**Re: Response to Comments**  
**PROPOSED BUILDING EXPANSION**  
**185 RAND ROAD, PORTLAND, MAINE**  
**CBL 254 A007001**

We have reviewed the staff review comments, received July 2 and July 15, and have prepared the following responses to address their concerns. The comments are reiterated in italics for reference with our response, in bold, immediately following:

TITLE: GRADING, DRAINAGE & EROSION CONTROL PLAN

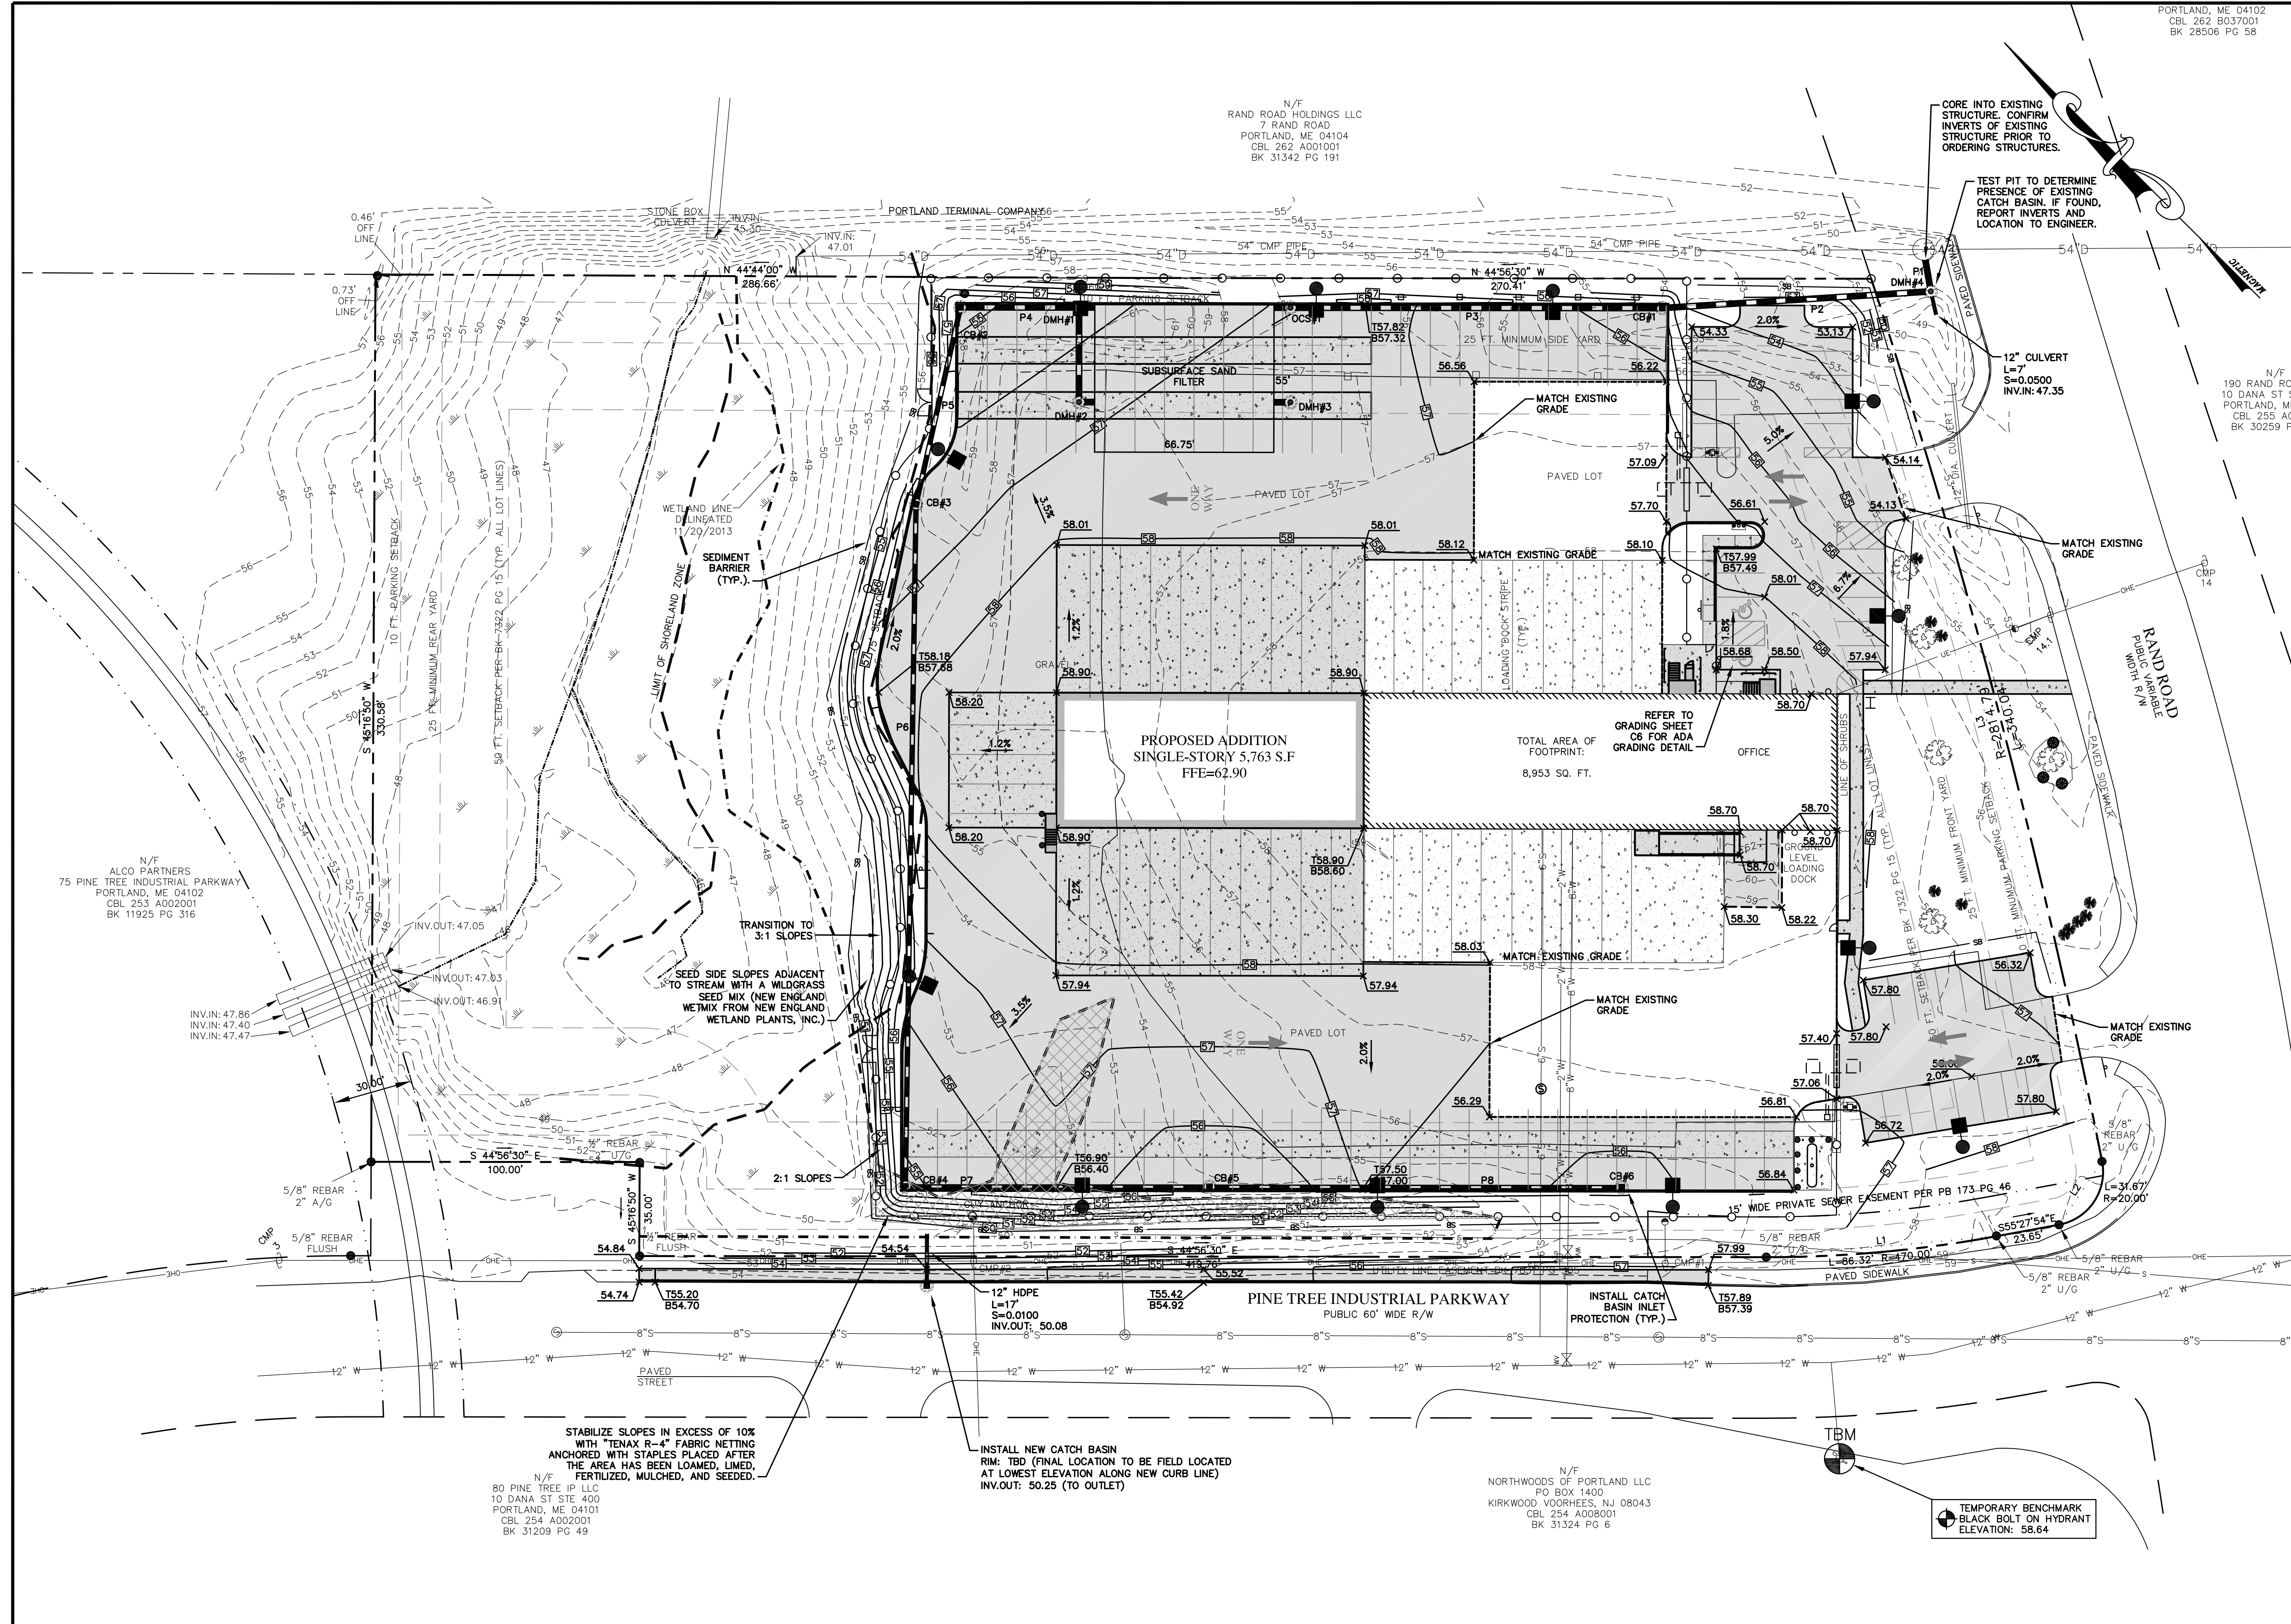
6. *Plan C-4, the Grading, Drainage, & Erosion Control Plan does show sediment barriers. 14-449(d) requires erosion and sedimentation control measures to apply all aspects of the proposed project and shall be in operation during all stages of activity in accordance with the "Maine Erosion and Sediment Control Handbook for Construction: Best Management Practices." Any exposed ground area shall be temporarily or permanently stabilized within one (1) week from the time it was last actively work with the appropriate materials. Any vegetation removed or damaged by the construction activities shall be replaced in kind and repaired.*

**The Erosion and Sedimentation Notes on sheet C8 – Erosion Control Detail and Notes cover the requested erosion control measures. Note 4 of the Temporary Erosion/Sedimentation Control Measures indicates that denuded areas shall receive mulch within thirty (30) days of initial disturbance or within seven (7) days after completing the rough grading operations. Note 1 of**

**the Permanent Erosion Control Measures indicates that all areas disturbed during construction will be loamed, limed, fertilized and seeded.**
